Application Ref:	3/2026/0209			 Ribble Valley Borough Council www.ribblevalley.gov.uk
Date Inspected:	8/4/24	Site Notice:	10/4/26	
Officer:	BT			
DELEGATED ITEM FILE REPORT:				APPROVAL

Development Description:	Variation of condition 2 (approved drawings) and 8 (land levels) to make internal and external amendments on permission 3/2025/0022 for the proposed demolition of front porch and replacement with new porch. Raising of roof. Construction of two-storey extension to side and single-storey extension to rear. Addition of new windows and insertion of rooflights. Construction of single-storey, pitched-roof, detached building containing borehole to supply filtered water supply to the property. Creation of garden area to rear and paved area to front.
Site Address/Location:	Higher Edge Farm, Tinklers Lane, Slaidburn, BB7 4TP.

SHEET: PROPOSED ELEVATIONS 1

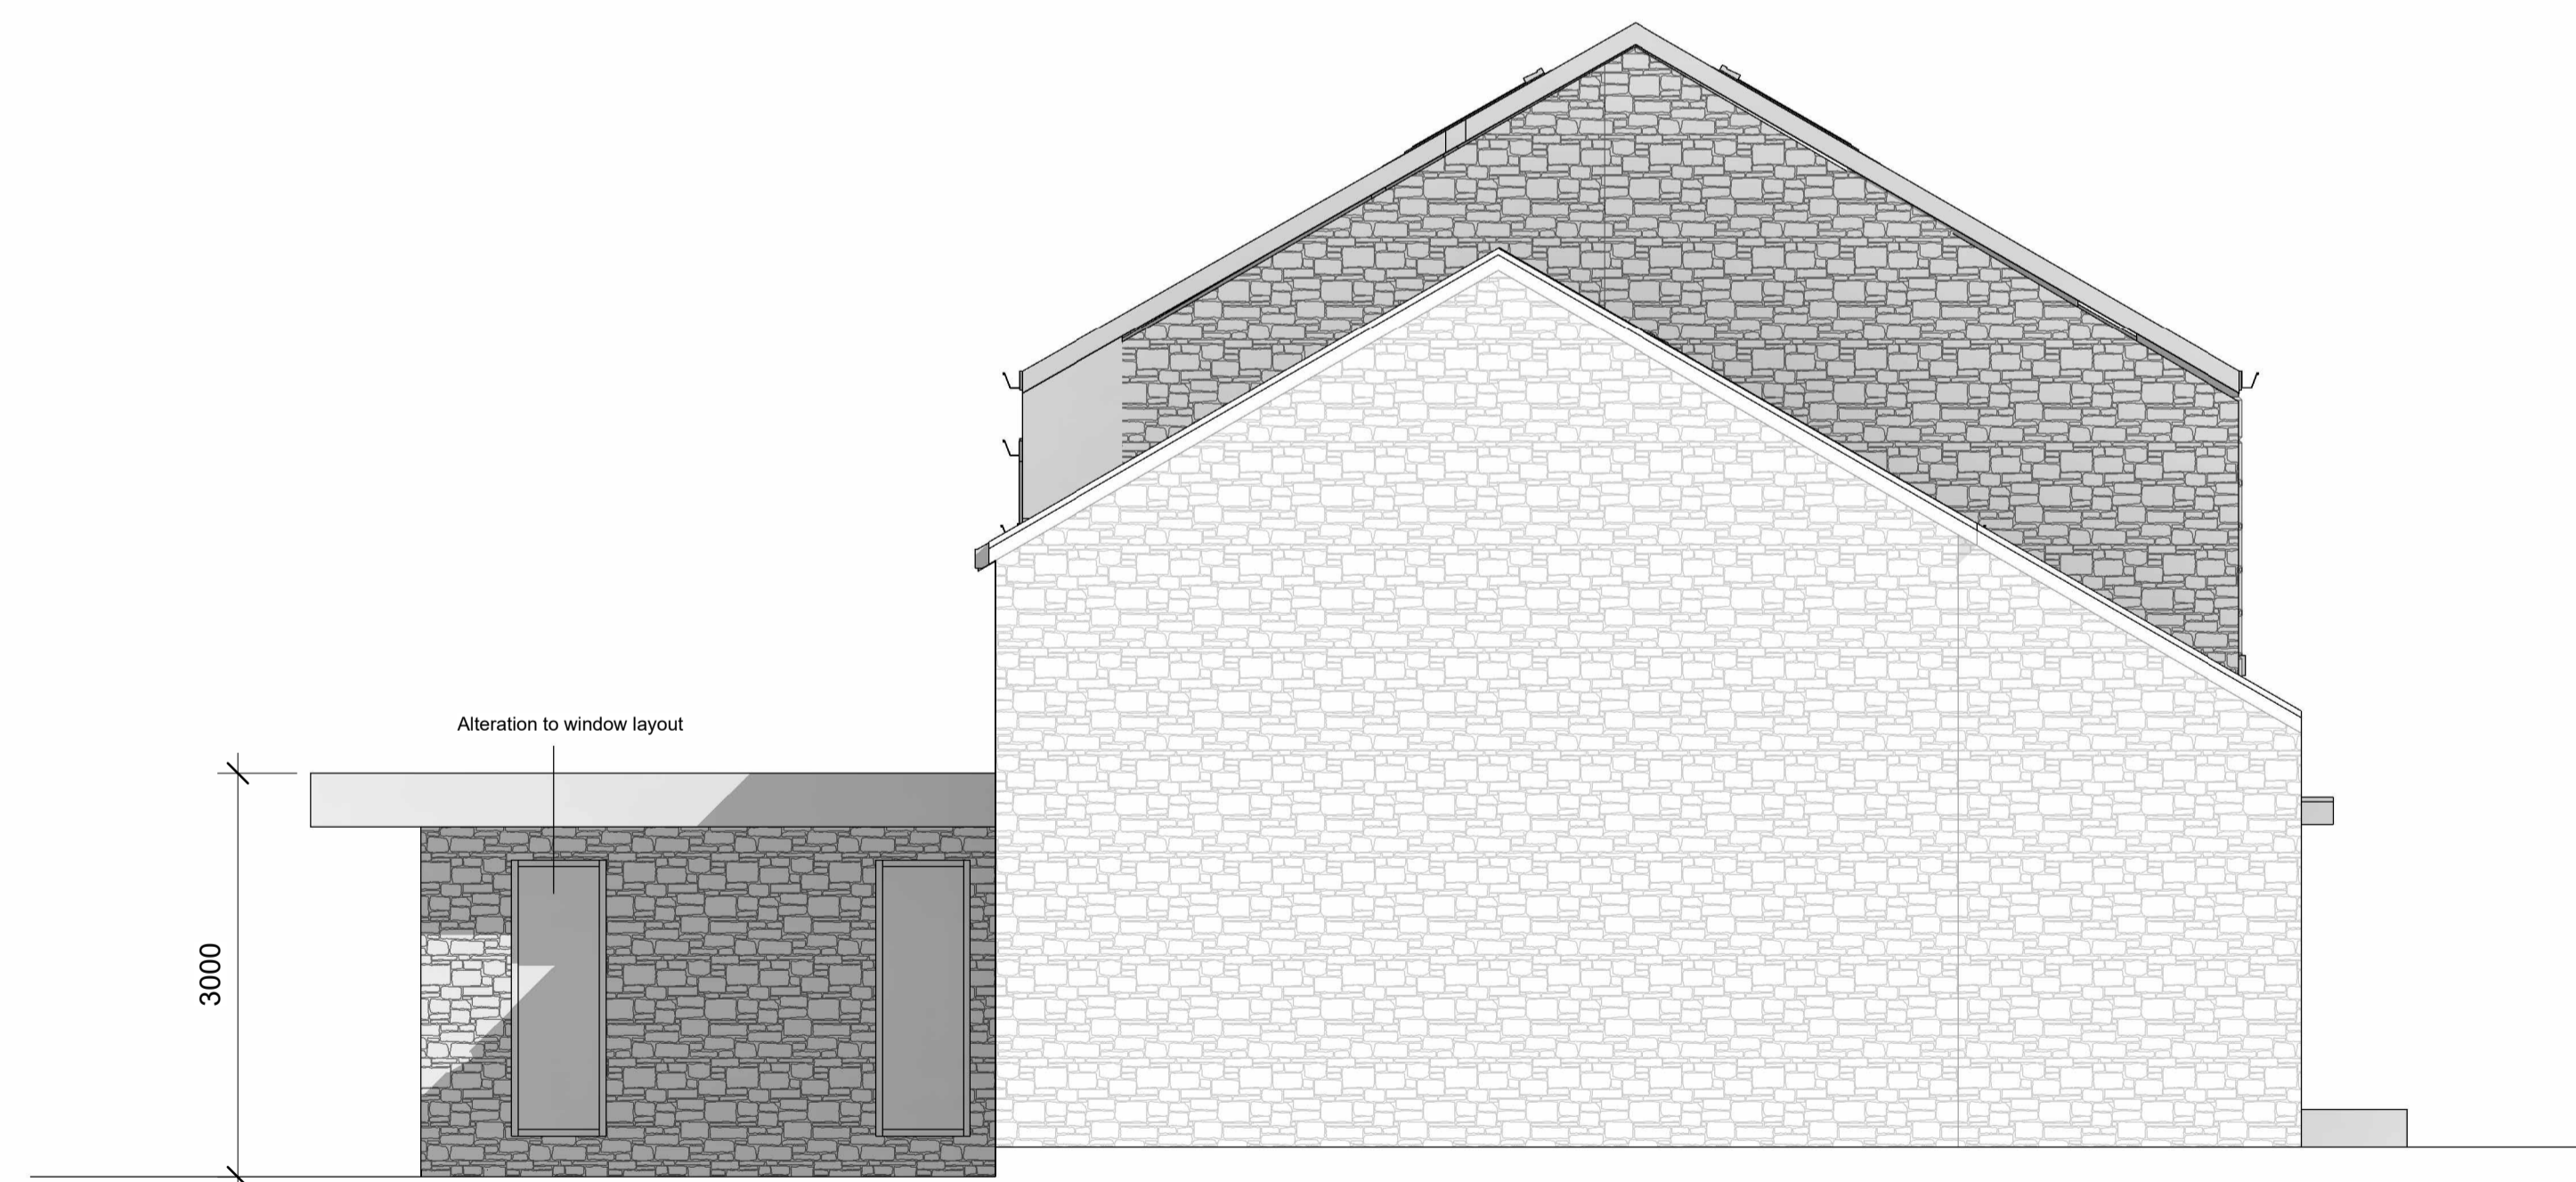
In this instance, the proposed amendment sought includes alterations to the solid to void ratio of fenestration across the Northern, Southern and Western elevations of the originally approved single storey extension and Western elevation of the farmhouse. In addition, two rooflight openings are proposed for the flat roof space of the approved single storey extension with an additional rooflight also proposed for the Eastern roofslope of the farmhouse. Four approved window openings are also to be omitted from the Eastern elevation of the farmhouse with existing ground and first floor window openings retained in their place. The aforementioned alterations to the approved scheme of fenestration would collectively amount to a minor change in visual terms relative to the approved design, with a sympathetic solid to void ratio of openings retained within the reconfigured pattern of fenestration.

Additional amendments to the originally approved scheme include the omission of a gabled front porch feature which is to be replaced with a flat roof door canopy. The proposed canopy feature would be simple in design and modest in terms of its height, width and outwards projection and as such would read as a discreet and congruent addition to the principle elevation of the farmhouse. The width and depth of the of the approved single storey extension's overhanging roof profile would also be increased as part of the proposed amendments however comparative analysis shows that these increases would be nominal in terms of size relative to the originally approved development. Similarly, the land level adjoining the rear

SHEET: PROPOSED ELEVATIONS 2

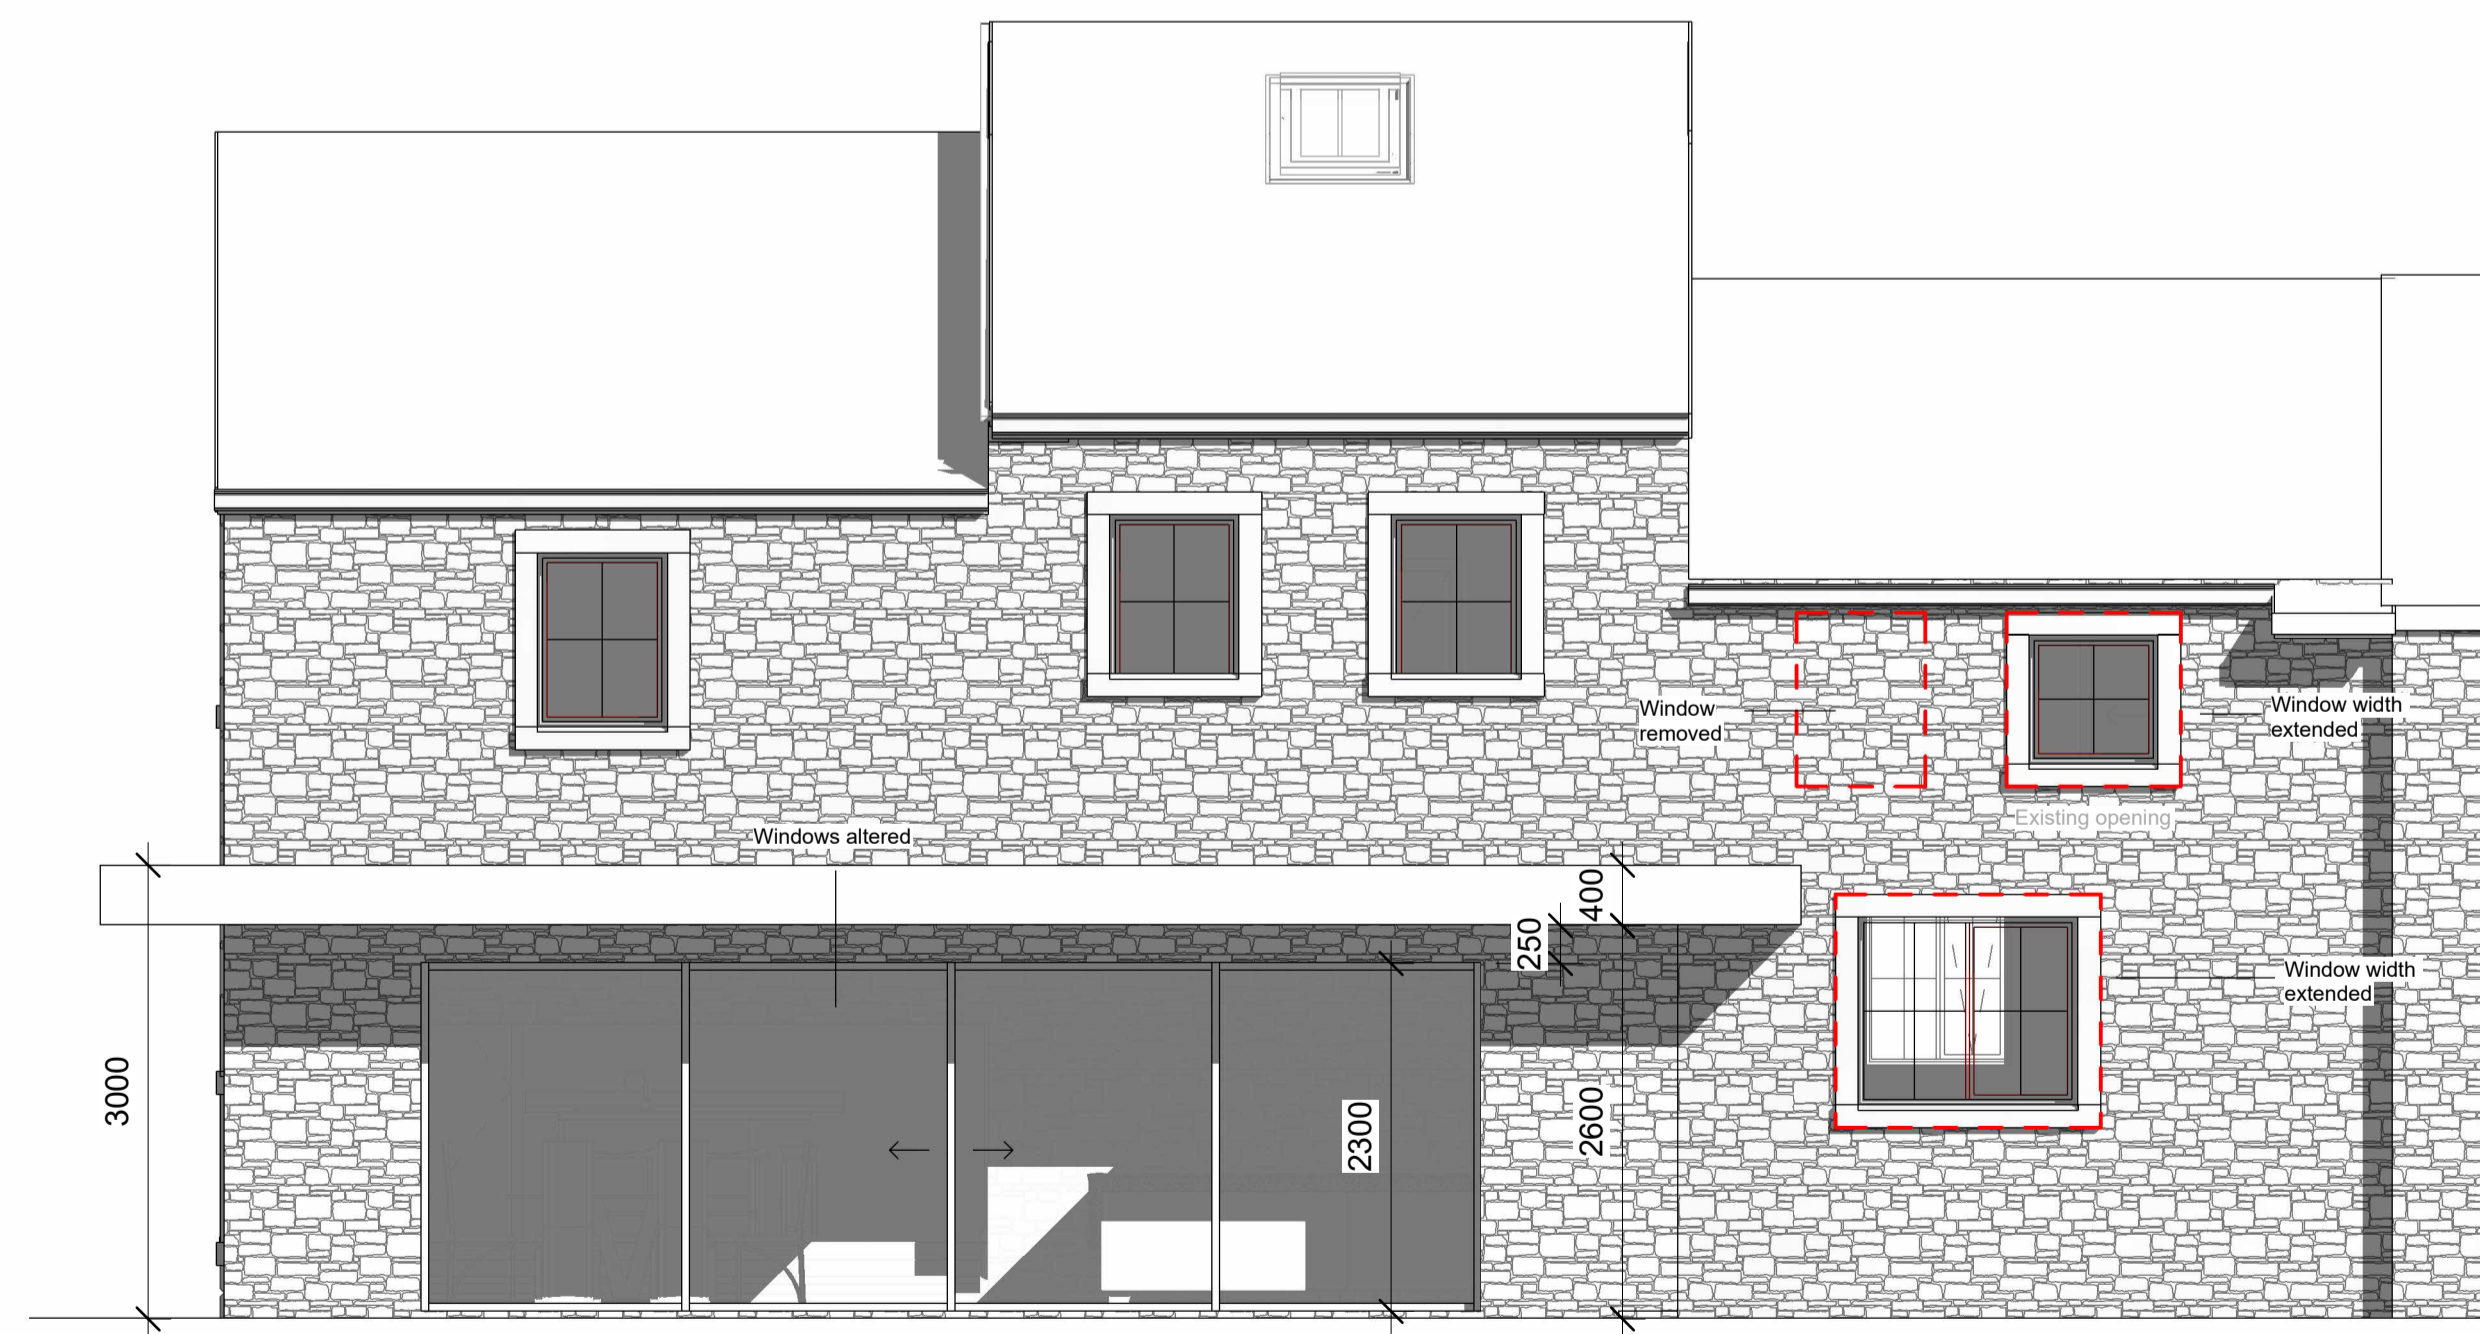
Western side of the farmhouse is to be raised as part of the proposed amendments which in turn would result in an increase in height to the approved single storey extension however this increase in height would also be nominal (350mm) whereby the single storey extension would still read as a subservient addition to the parent property.
